**THE SIZEWELL C PROJECT**

**EN010012**

**Deadline 7: WRITTEN SUBMISSION OF ORAL CASE (ISH10) and  
EXPERT COMMENTS on ISH10**

# PAK-HA-3 Hydrograph

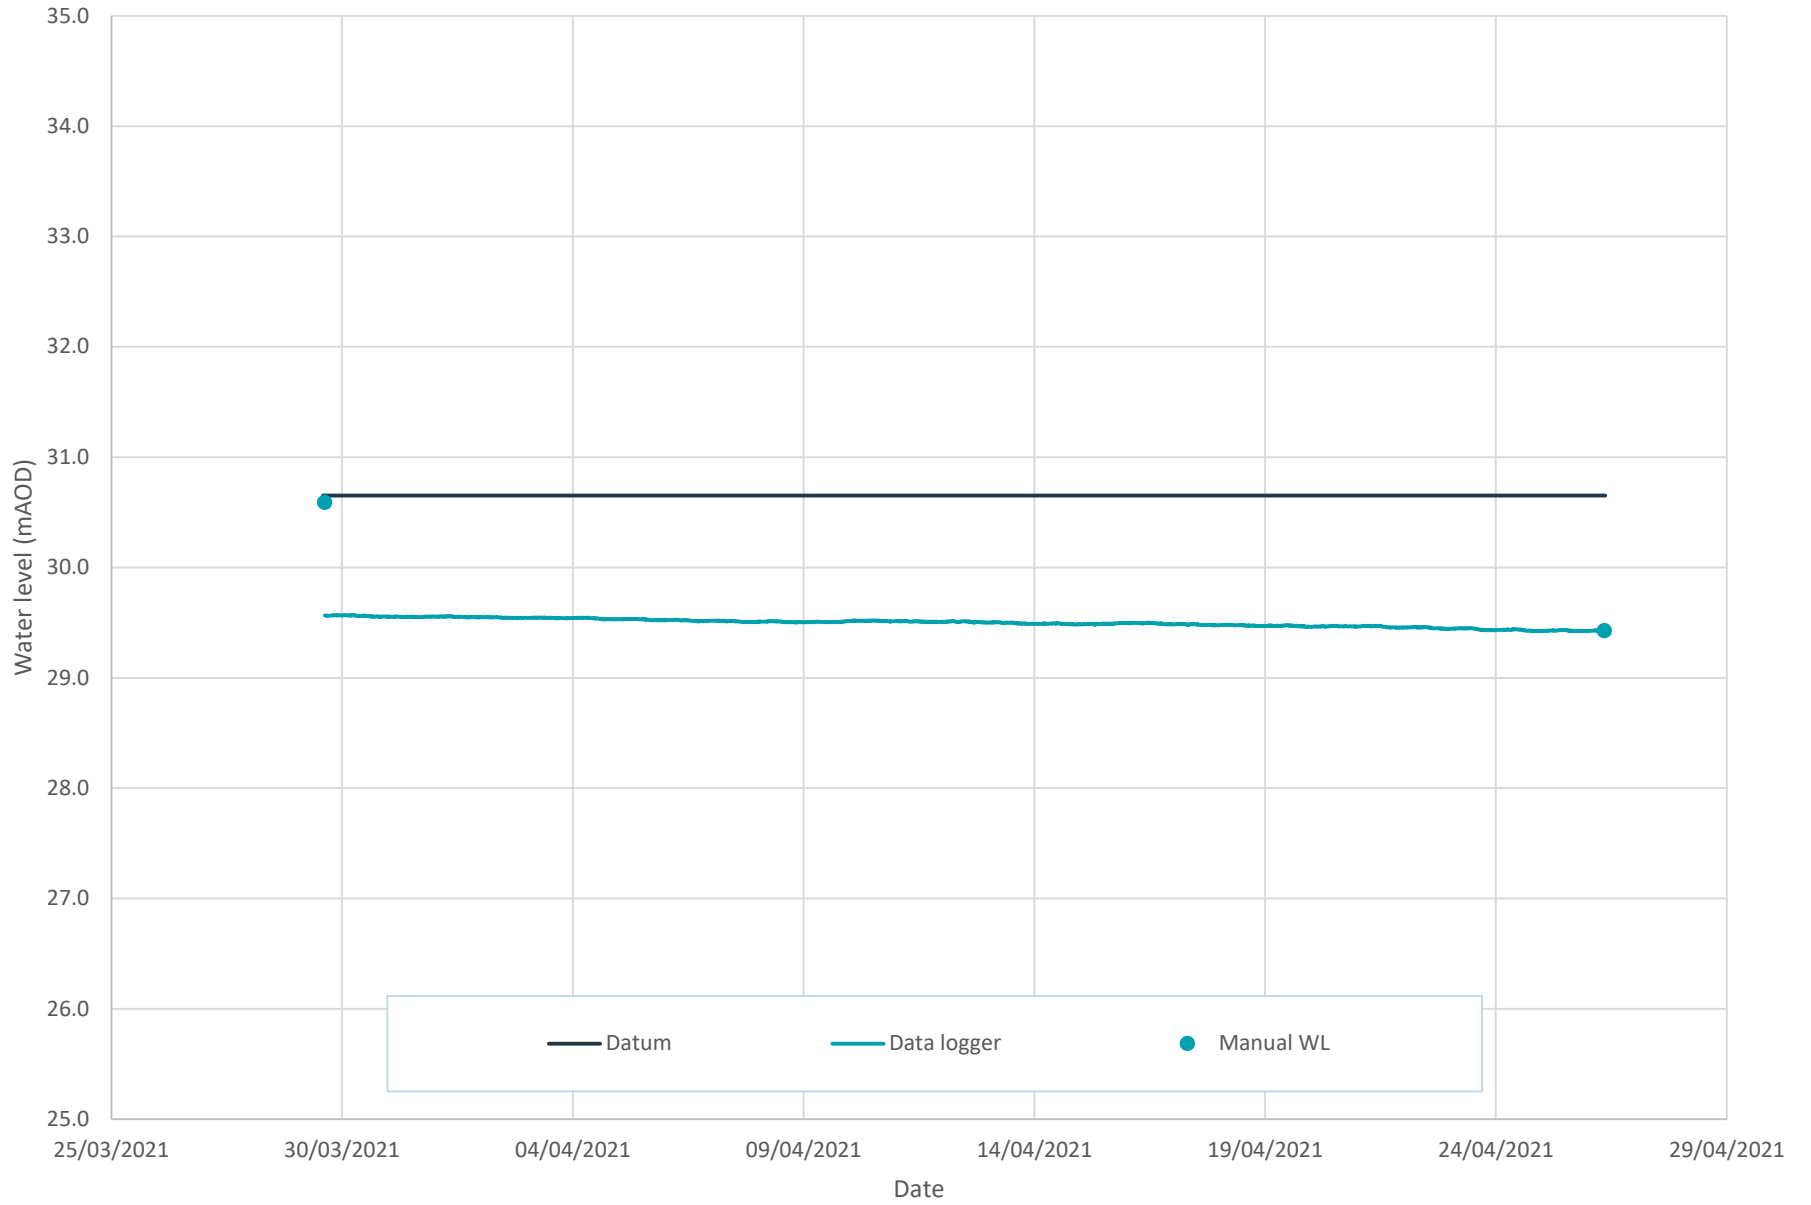
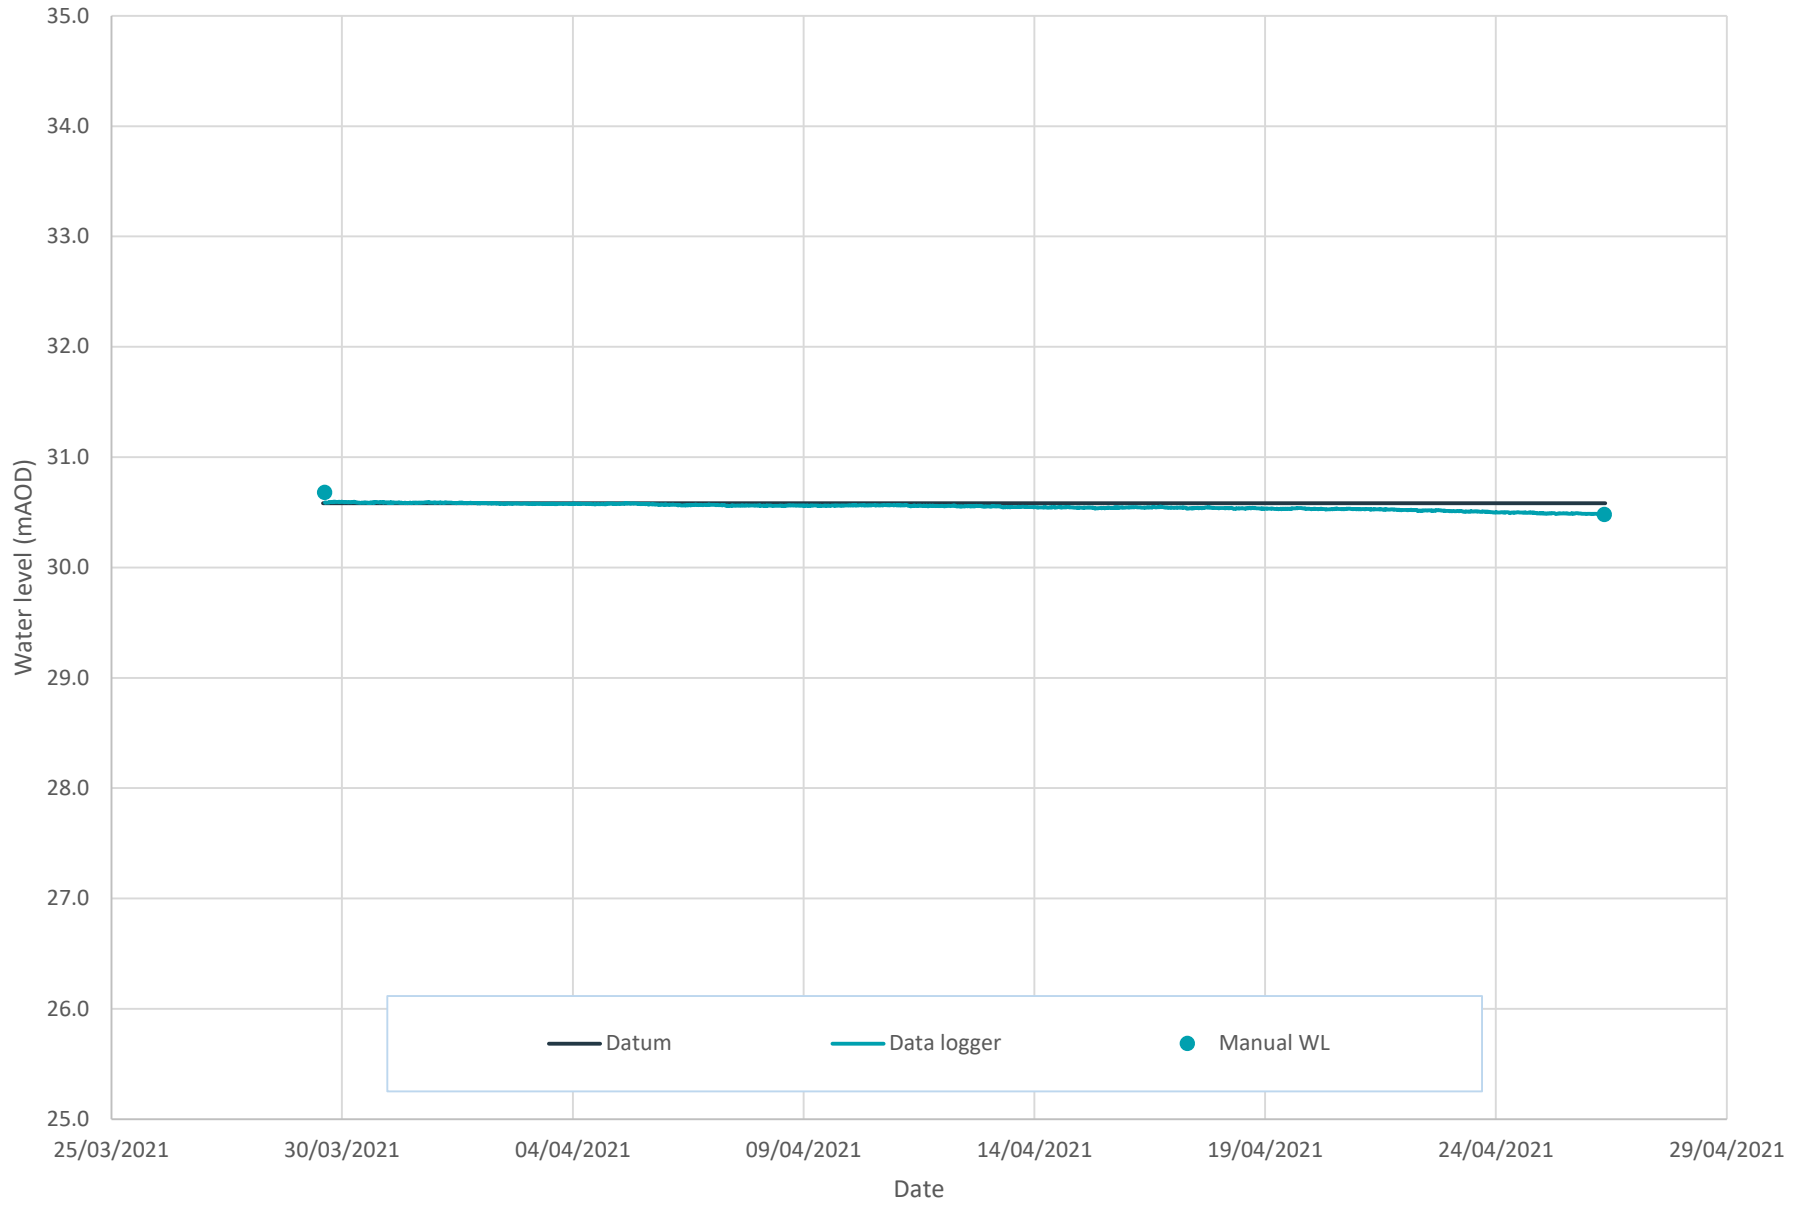
This assessment should have sufficient time to be fully reviewed and signed-off by the applicant’s consultants. The current submissions show significant signs of poor-quality collection and/or processing of water level data. Examples are on pages 261, 262 and 264 of PINS reference REP3-052 (full reference below), where there is very poor correlation of manual and logged data points, which has no associated explanation.

At Pakenham, there is a need for the third-party abstraction to cease, but there is no discussion around whether this is likely.

Again at Pakenham, we are concerned that water levels might be too low here for effective habitat creation in summer months. Wheeler *et al.* (2009) suggests summer water levels down to 1.75 mbgl are possible, but this is exceptional and in drought conditions and would not be expected to be observed in a short record outside drought conditions. Note that one month of “exceptionally dry” conditions (see above) does not constitute an established drought, and it is not considered that we are currently experiencing such an event. It is also important to note that if the restoration is
